Application by National Highways for an Order granting Development Consent to authorise the widening of an approximately 20.6km stretch of the existing A1 from Morpeth to Ellingham, with approximately 14.5km of online widening and approximately 6.1km of new offline highway

Thank you for consulting with Northumberland Wildlife Trust (NWT). Apologies for my short response and lack of knowledge of previous documents, as I have just received this consultation due to staff changes. Whilst NWT do not object to the proposals, and understand that a vast amount of work has already gone into or is proposed for the application, we have some concerns with the details of mitigation offered and whether a detailed LEMP will be provided. In addition to our previous correspondence, we have the following comments on the documents provided in the link:

**Key**

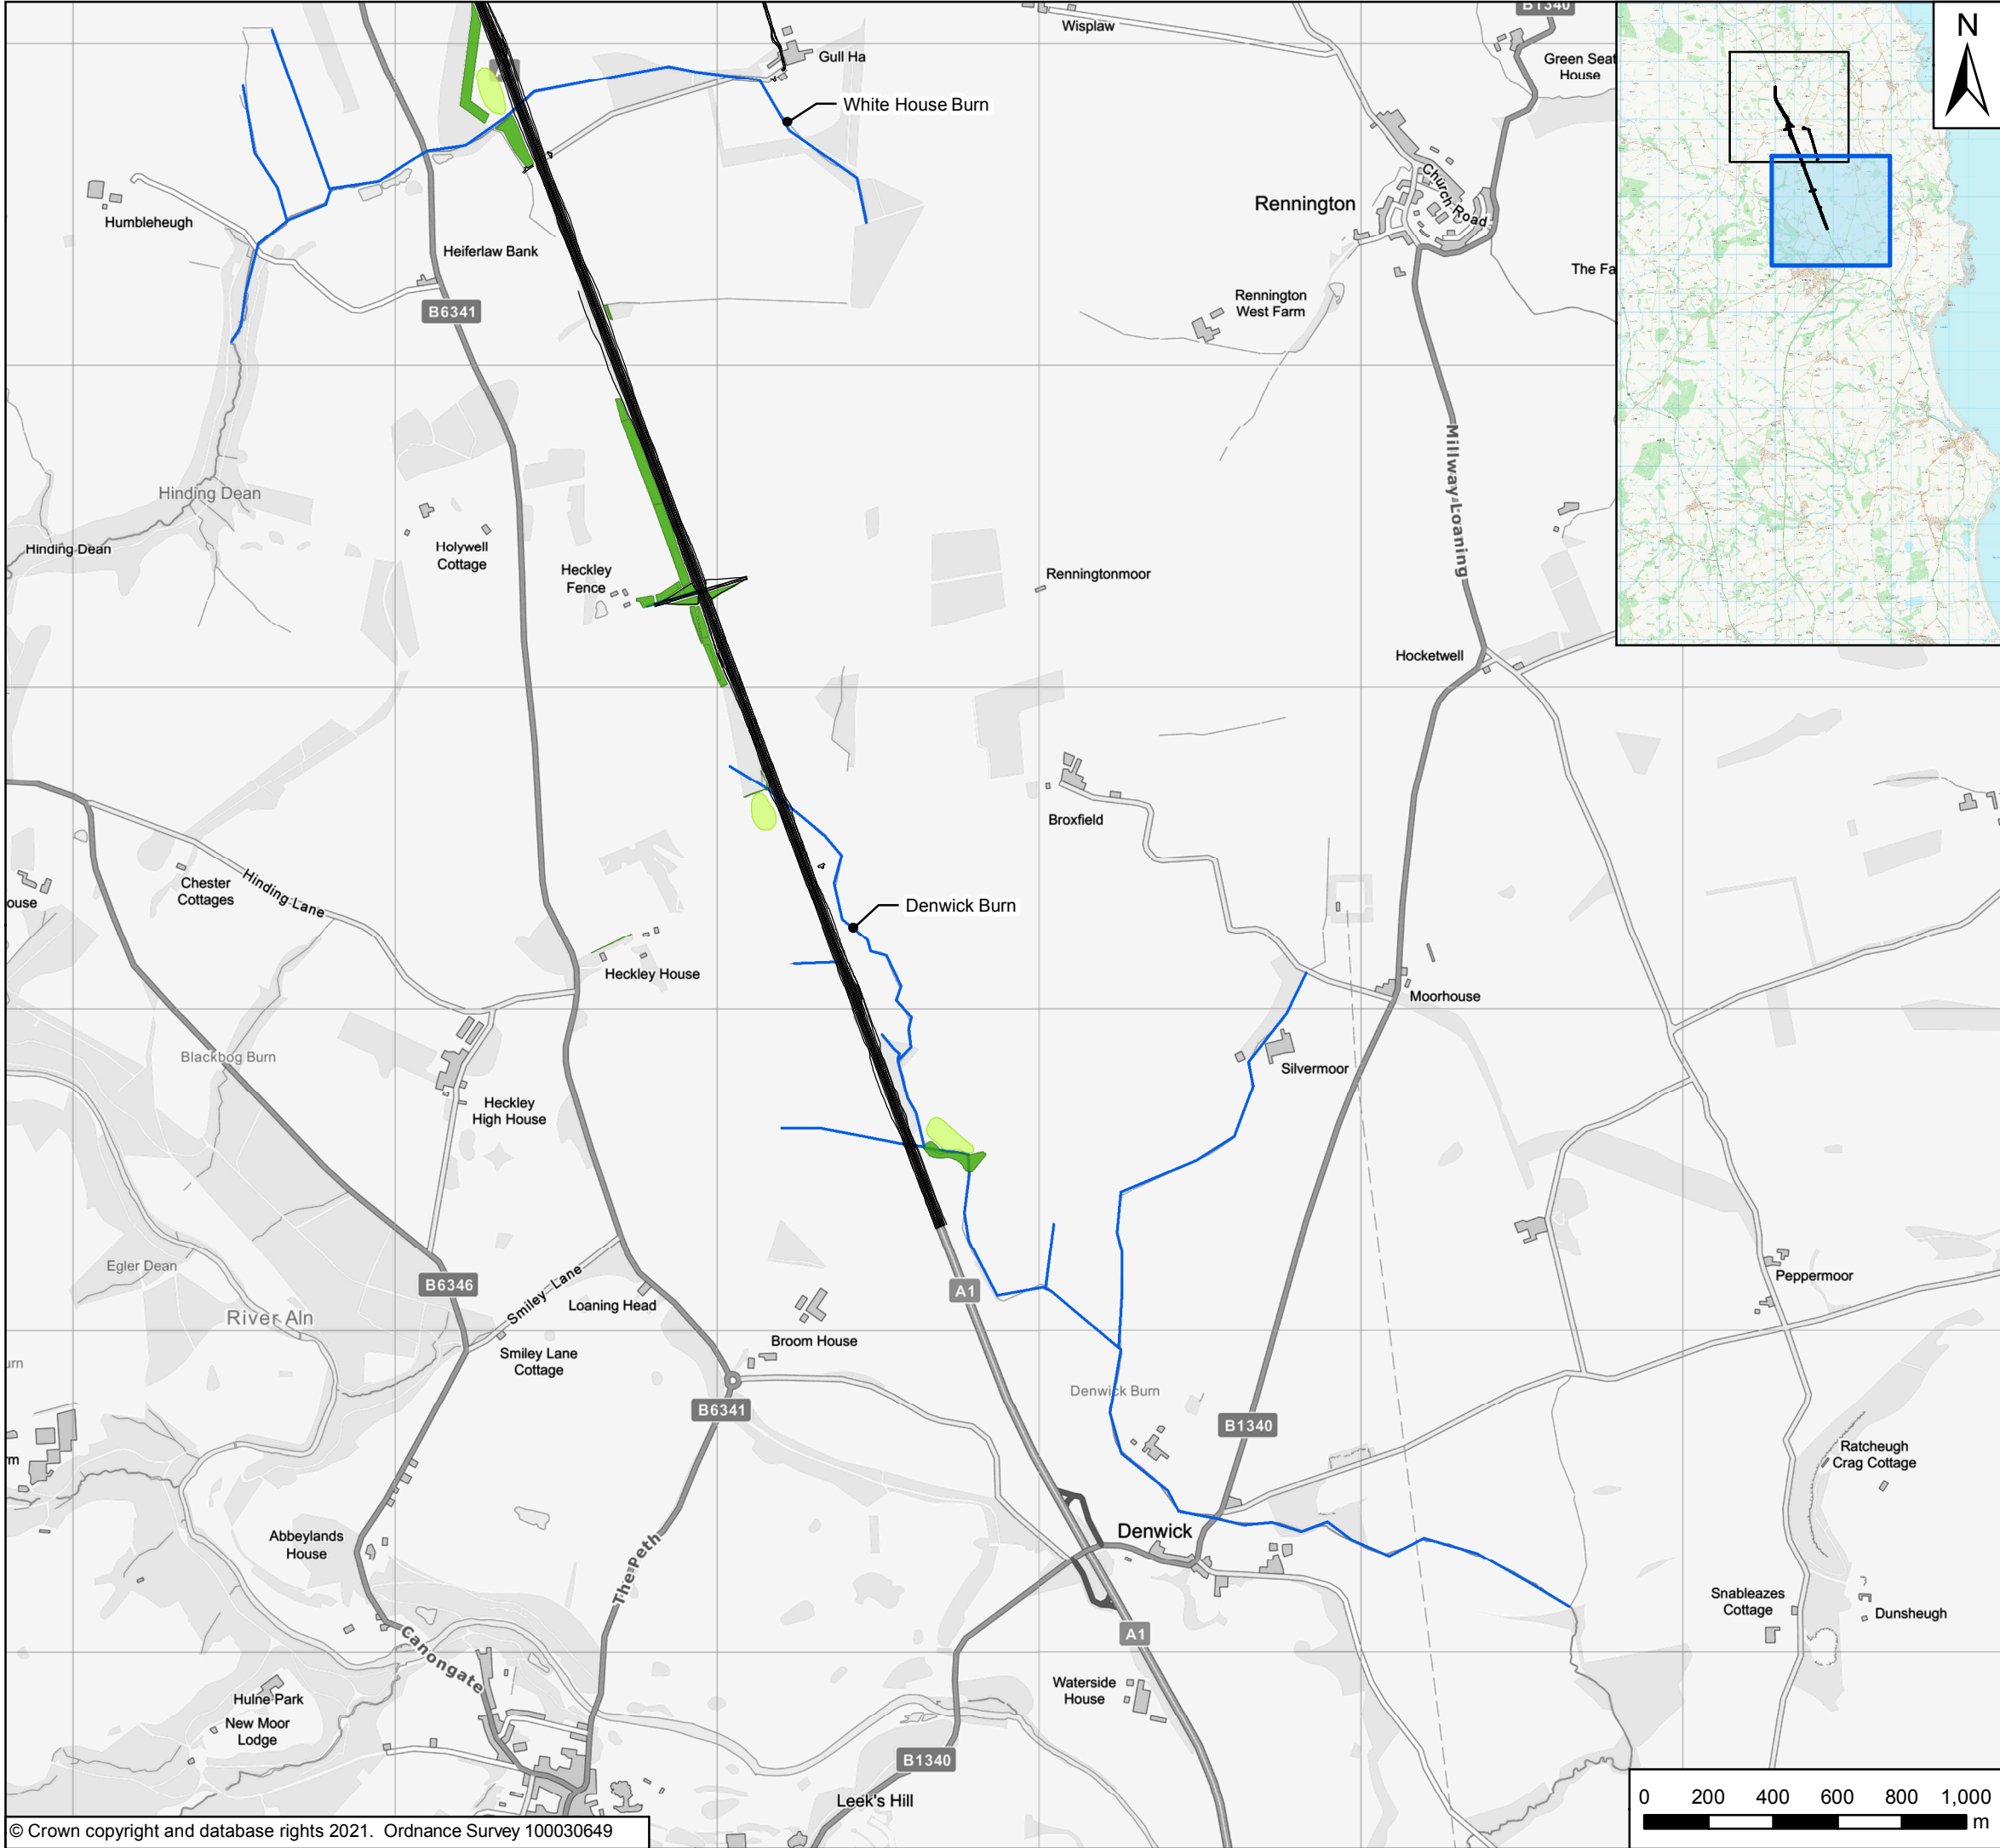
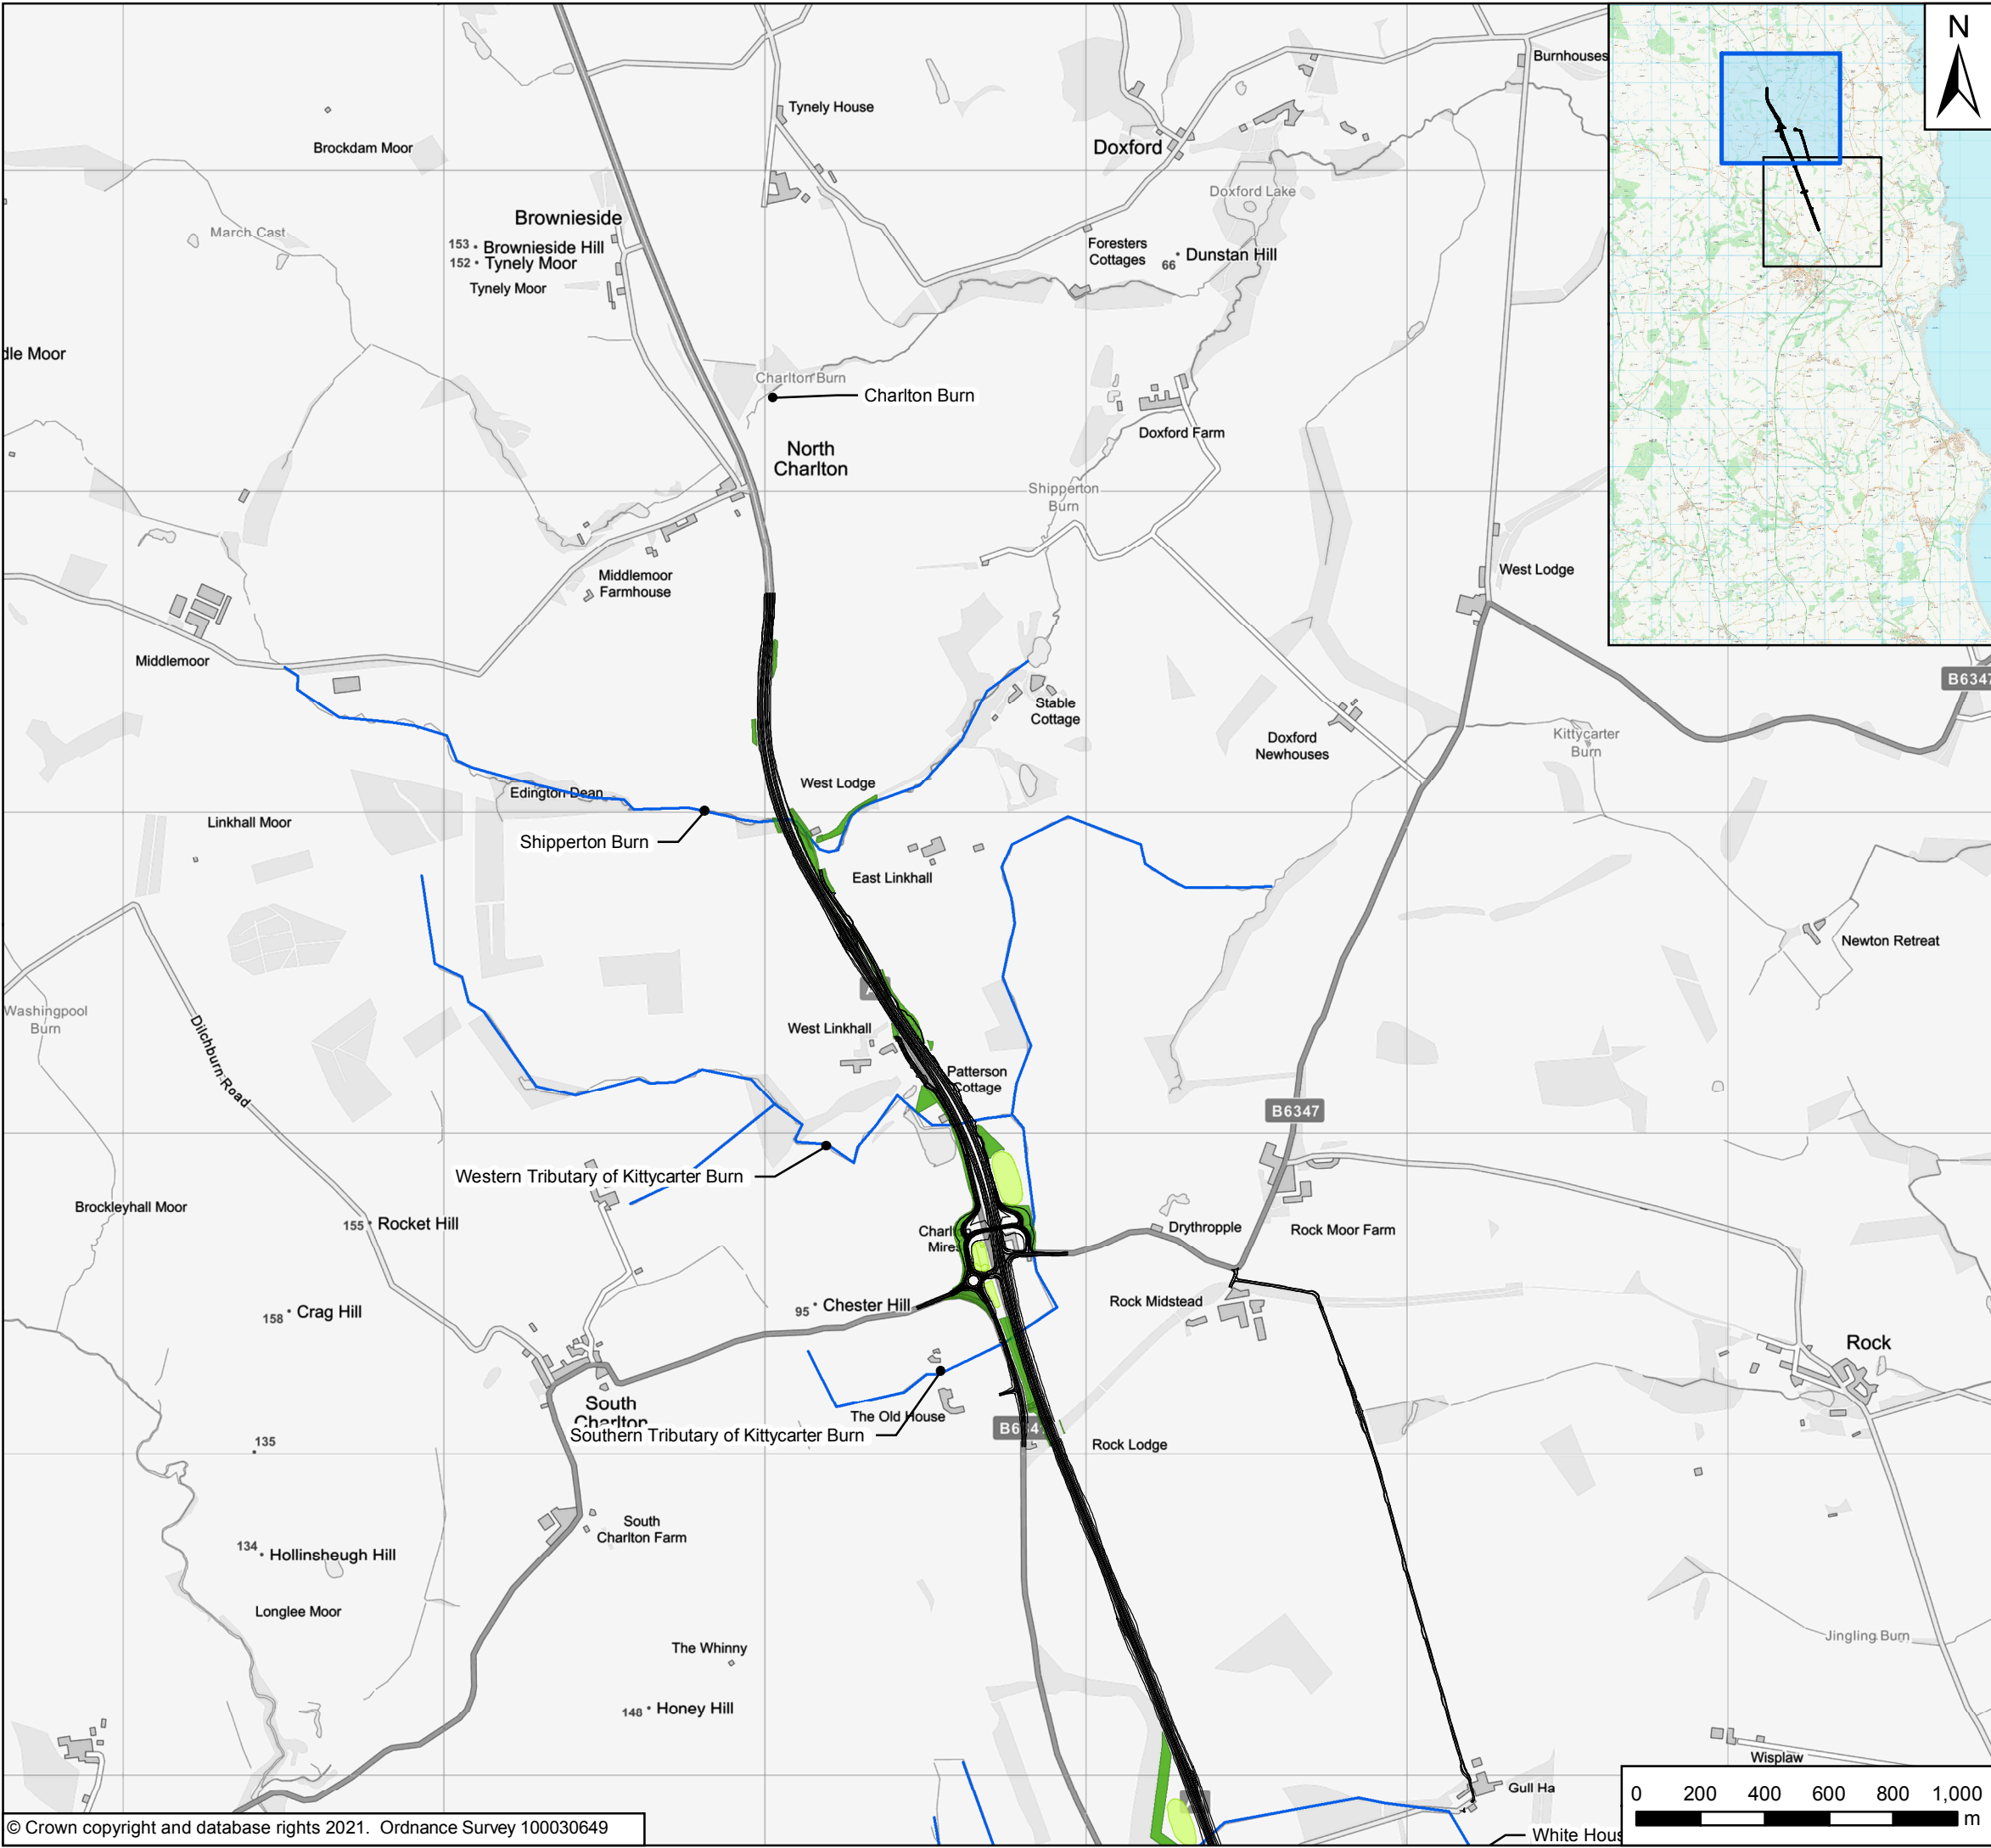
NWT would always request that all species used in the landscaping (for all habitats) be appropriate locally native species, not just UK native, and that hedgerows are species rich with 8 or more species. The ancient woodland species mix proposed on the landscaping plan (available through the link) includes horse chestnut, which is **not** native and beech which is not locally native and introduced to Northumberland. We would request that these two species be removed, if not already and a more appropriate species be used. In the indicative woodland block planting mix, beech and large-leaved lime are listed. Again, these species are not locally native and we would request that these species be removed from the list. While beech is a UK native, it will out compete and shade out locally native species, while the heavy and persistent leaf litter will smother groundflora and greatly reduce natural regeneration and biodiversity. Considering the amount of work that has gone into the proposals, this is a minor alteration and by including more appropriate species there should be positive impacts rather than negative impacts.
